# PORTLAND MAINE

April 29, 2009

RE: 113 Lane Avenue – 310 D014 – R-3 – garage addition – permit #09-0259

Plot Plan

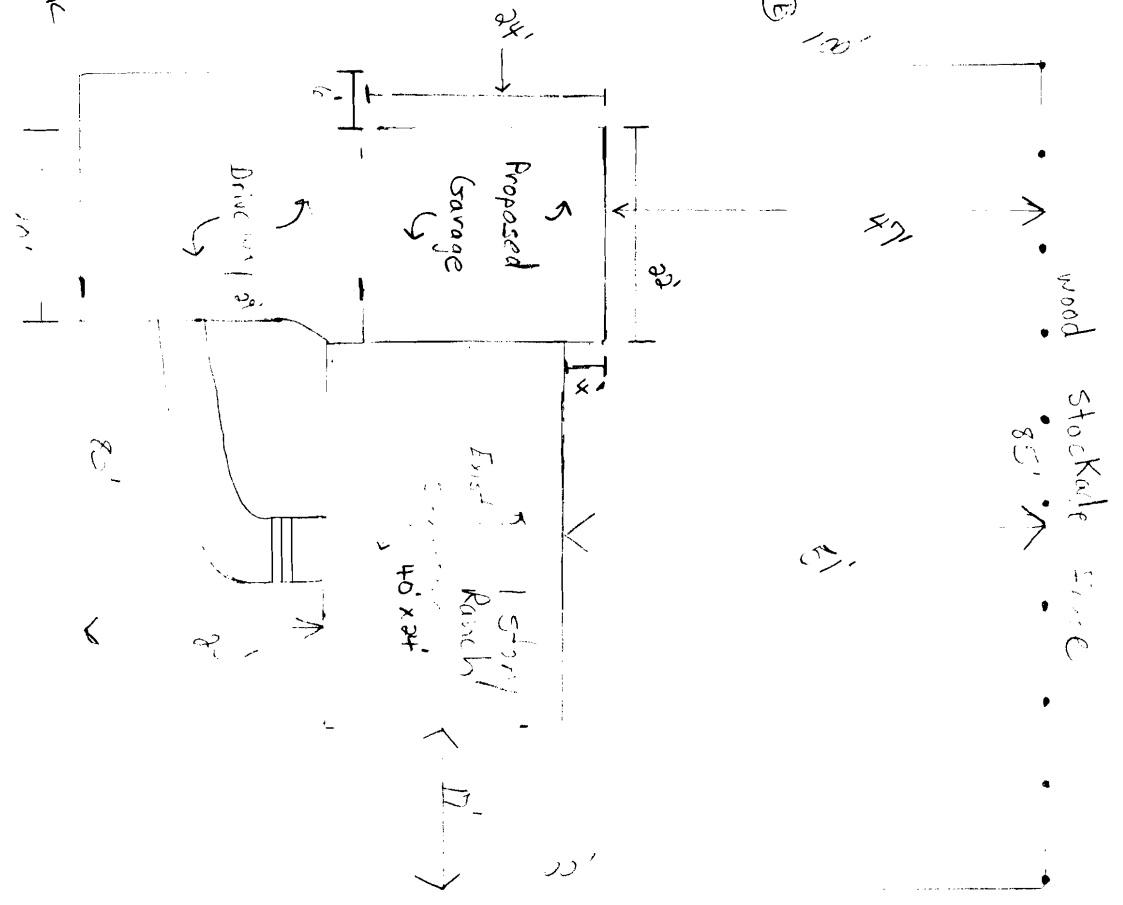
Section 14-90(d)(3)(a) of the ordinance gives eight feet as the minimum side setback for a one story structure. The plot plan that was submitted with the application gives the side setback to the property line from the proposed garage as six feet. This does not meet the minimum eight foot setback requirement.

As I told you on the telephone, if you reduced the proposed garage width to twenty feet then according to the plot plan (the distance would have to be verified), the setback would be eight feet, and this would meet the dimensional requirement. You said that you needed a two car garage. The Technical and Design Standards and Guidelines for the City of Portland give the width of a parking space as nine feet, so a twenty foot wide garage should be able to hold two cars.
